Mt Piper Power Station Extension

Submissions Report

Mt Piper Power Station Extension Environmental Assessment

SUBMISSIONS REPORT

■ **Figure 10 Ranked comparison of measured and predicted SO₂ concentrations**

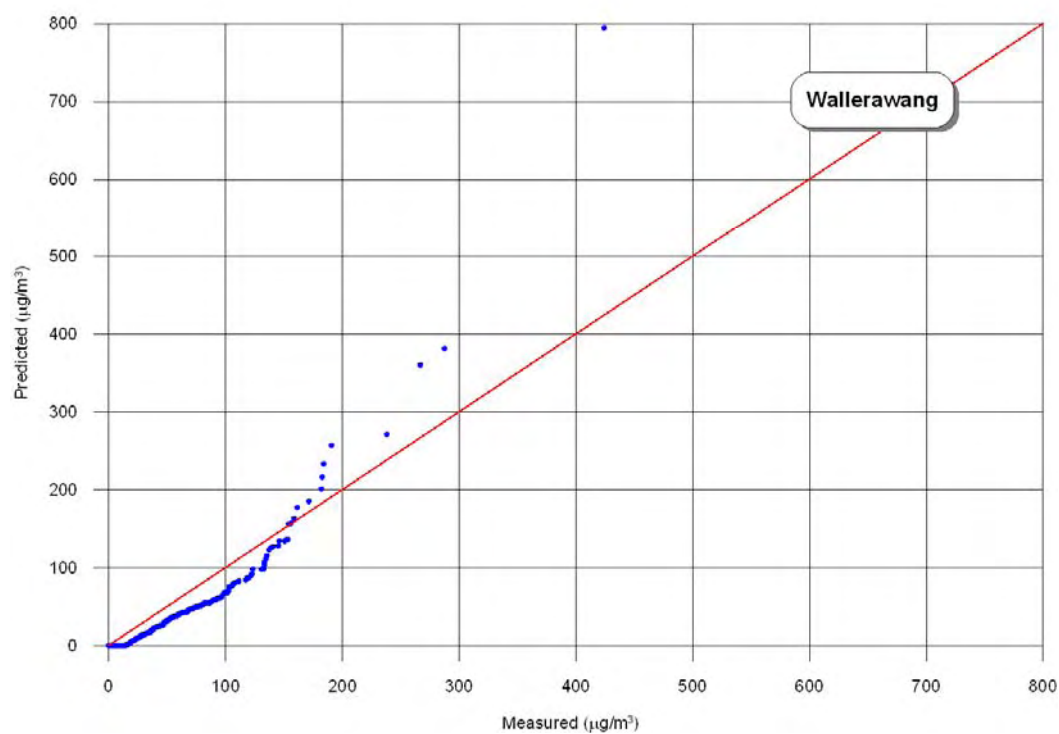
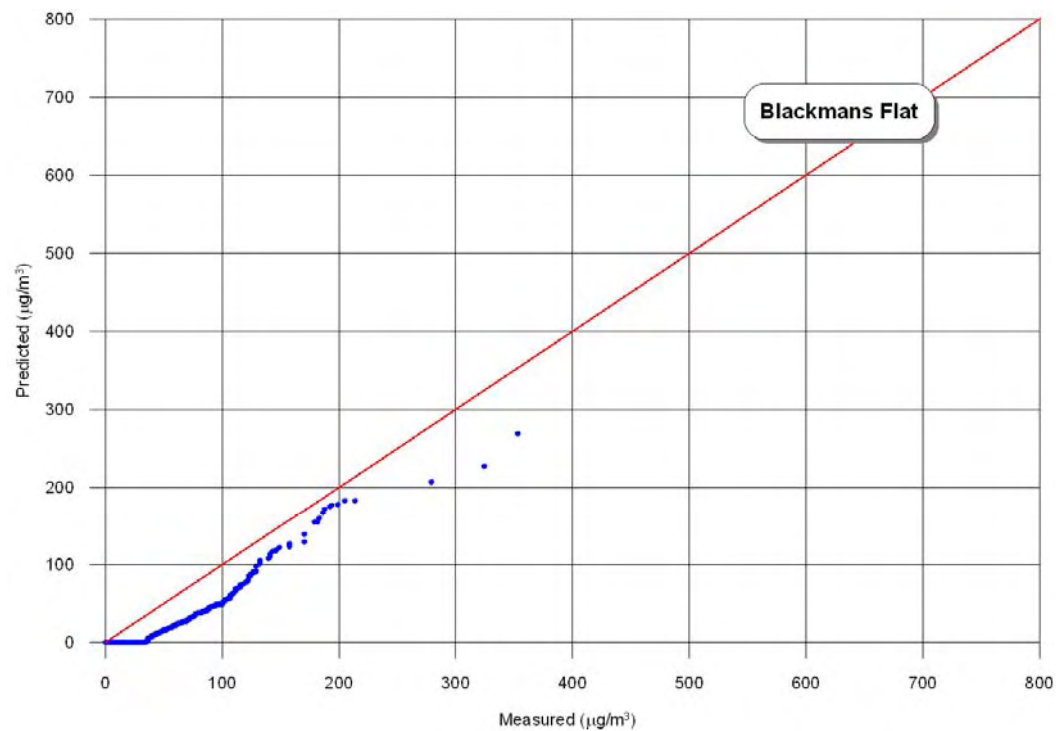
The assessment states that the modelled second and third highest concentrations show better agreement with measured maximums at some locations. The second highest model prediction is closer to the maximum measured-hour SO₂ concentration at Wallerawang, based on Figure 10 of Appendix E. However, the second highest model prediction would under-predict the maximum measured concentration by ~ 50 µg/m³. Additionally, based on the results for Blackmans Flat, the use of the second highest model prediction would not be appropriate for use at all locations across the model domain.
